Onejoy Place
Site Plan Review
Bill Scott
9/20/2017

Recording Plat

**RECORDING PLAT**  
AT  
1 JOY PLACE, PORTLAND, MAINE  
MADE FOR OWNER OF RECORD:  
**ONEJOY PLACE LLC**  
TWO UNION STREET, 5TH FLOOR  
PORTLAND, MAINE 04101

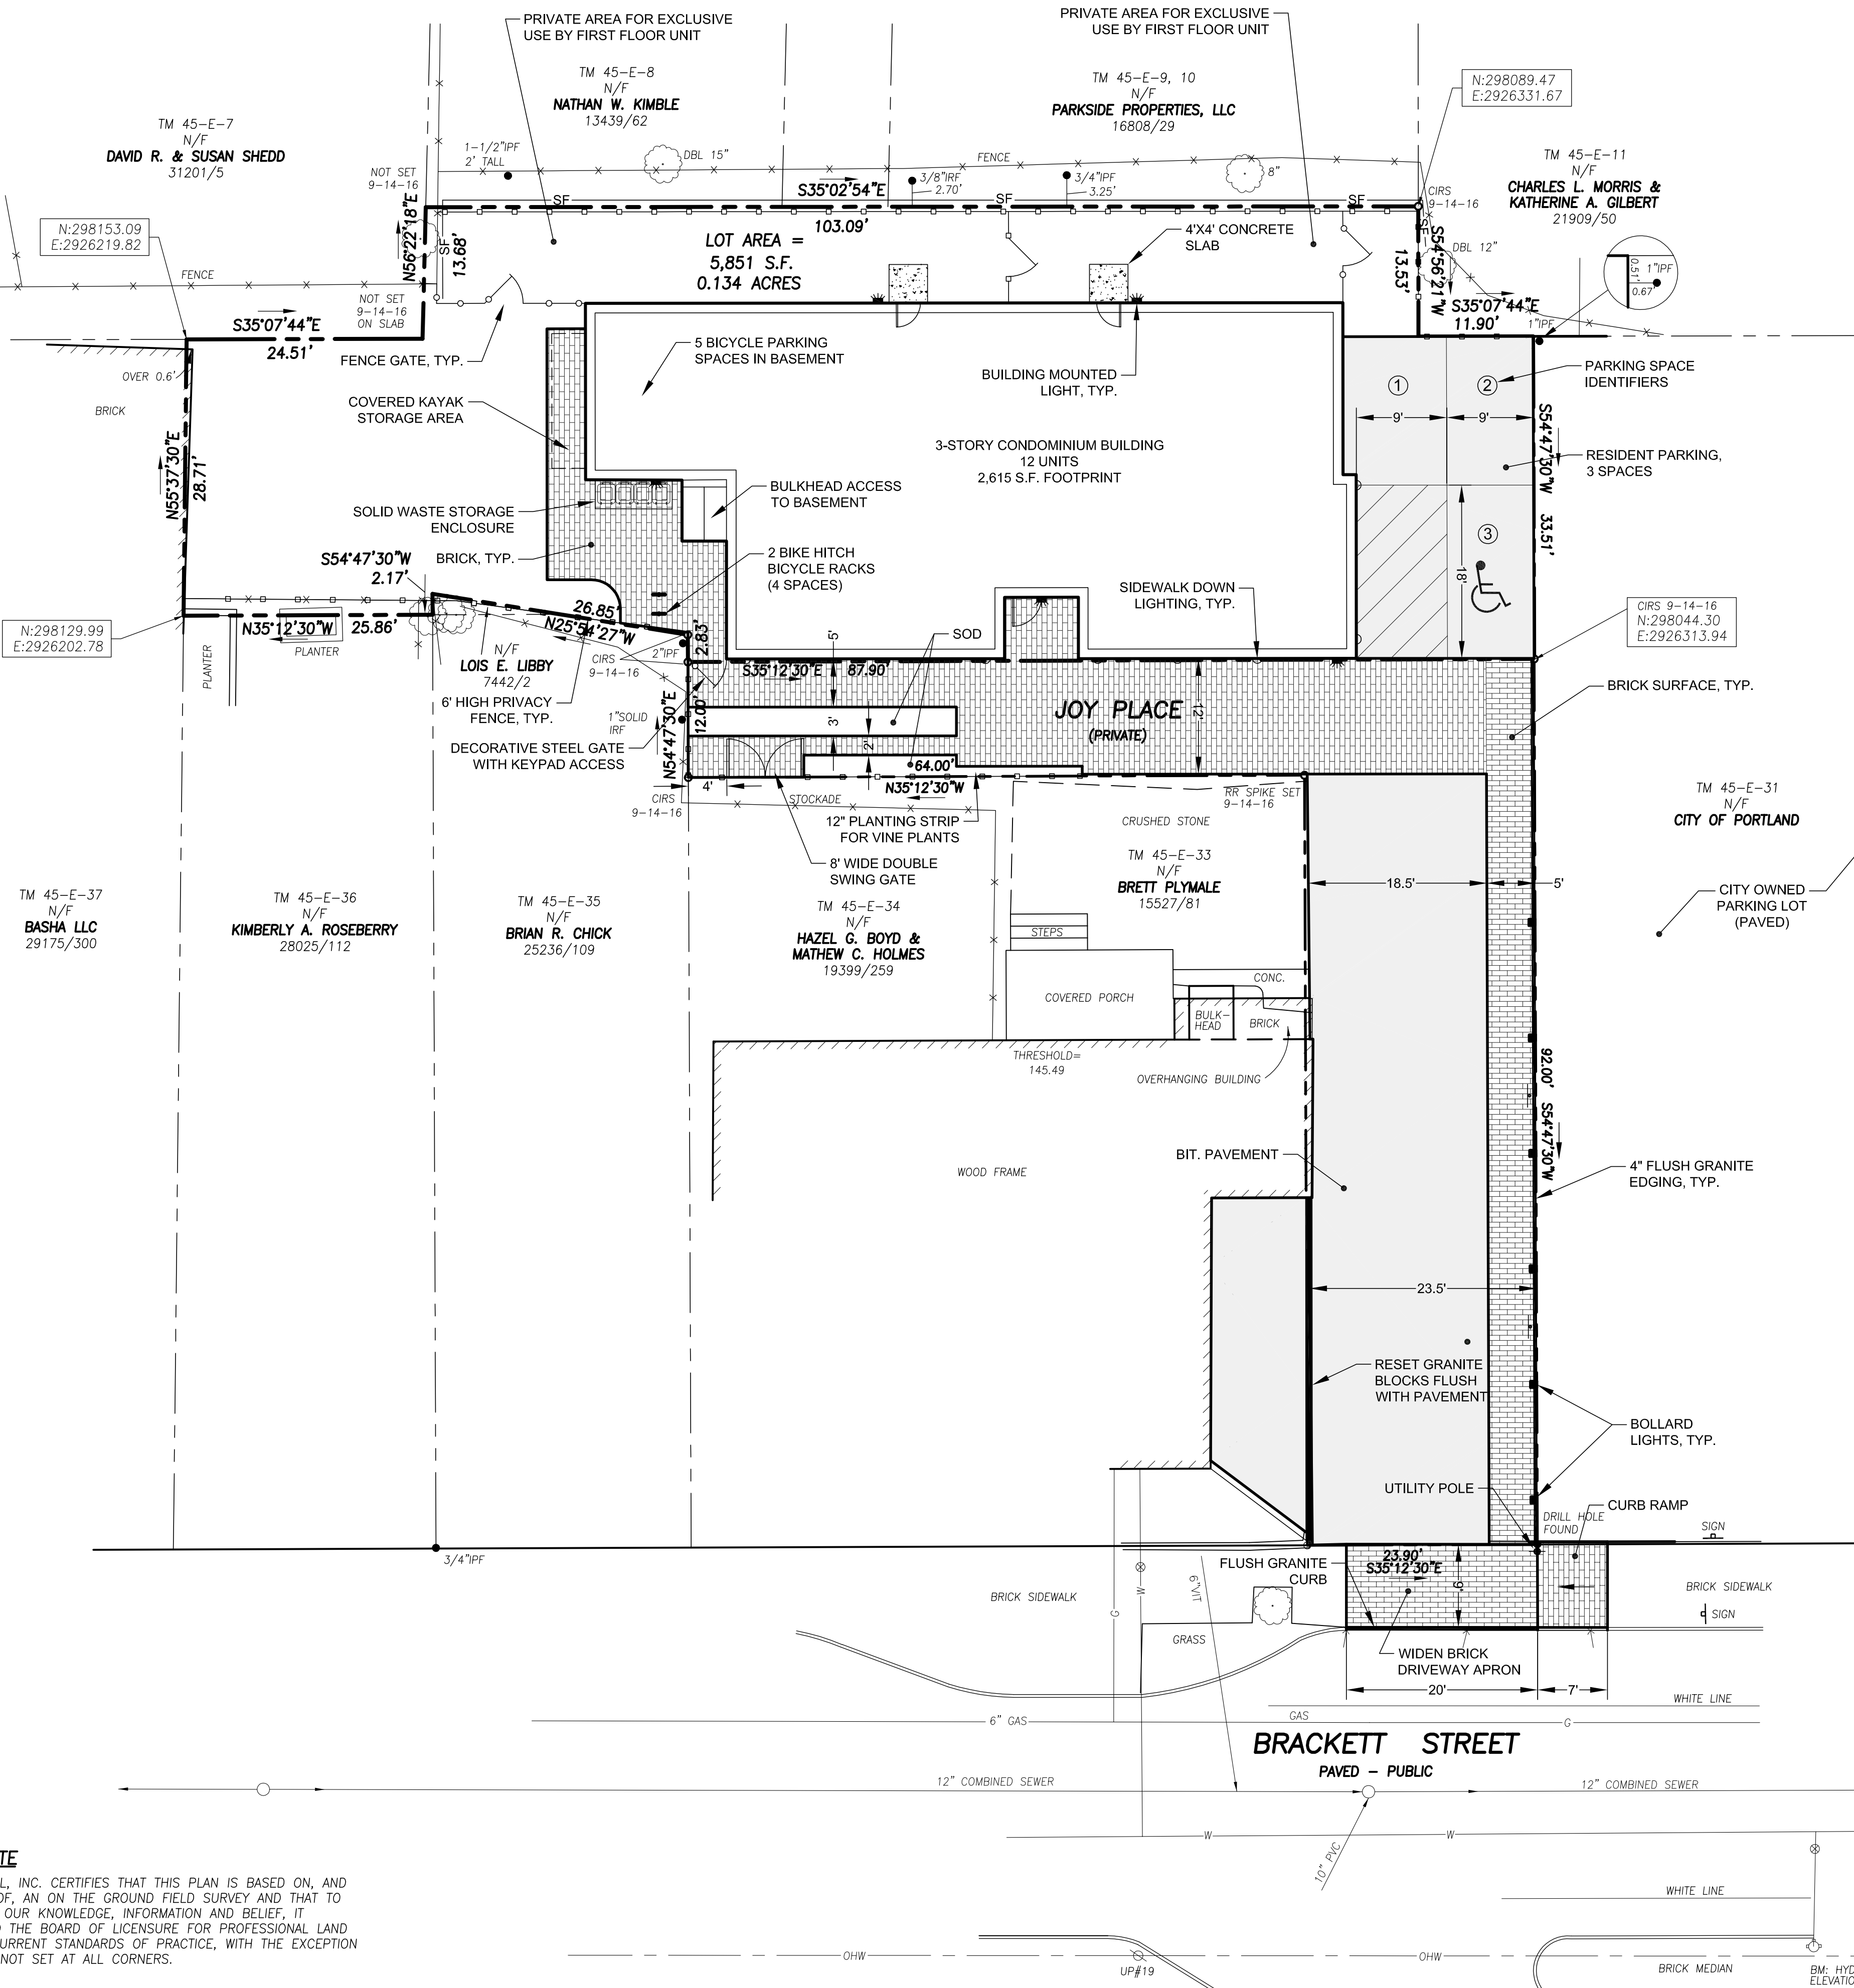
1. Joy Place is labeled as "Private". Who has the rights to use it? Is it just this development or do any of the abutters benefit from its use as well? And who is responsible for maintenance and repair of this road? I think the surveyor should add a note that spells out some of these details so that there's no confusion later on.
2. The boundary figure is missing a bearing and distance label along the northwesterly side of Joy Place as it connects to Brackett Street.
3. The surveyor needs to add a description and elevation of the City Benchmark that was used as the basis for the elevations referred to in Note 4.
4. Is there a set back that's required for the proposed building near the corner of Brian Chick's land? It looks like that is the portion of the new building that comes closest to an abutting boundary line.

All of the plan sheets that have elevations shown (i.e. Grading plan, Utility plan, Existing Conditions plan) should have a note that identifies the elevation datum and that references the survey by Owen Haskell and the Recording Plat.
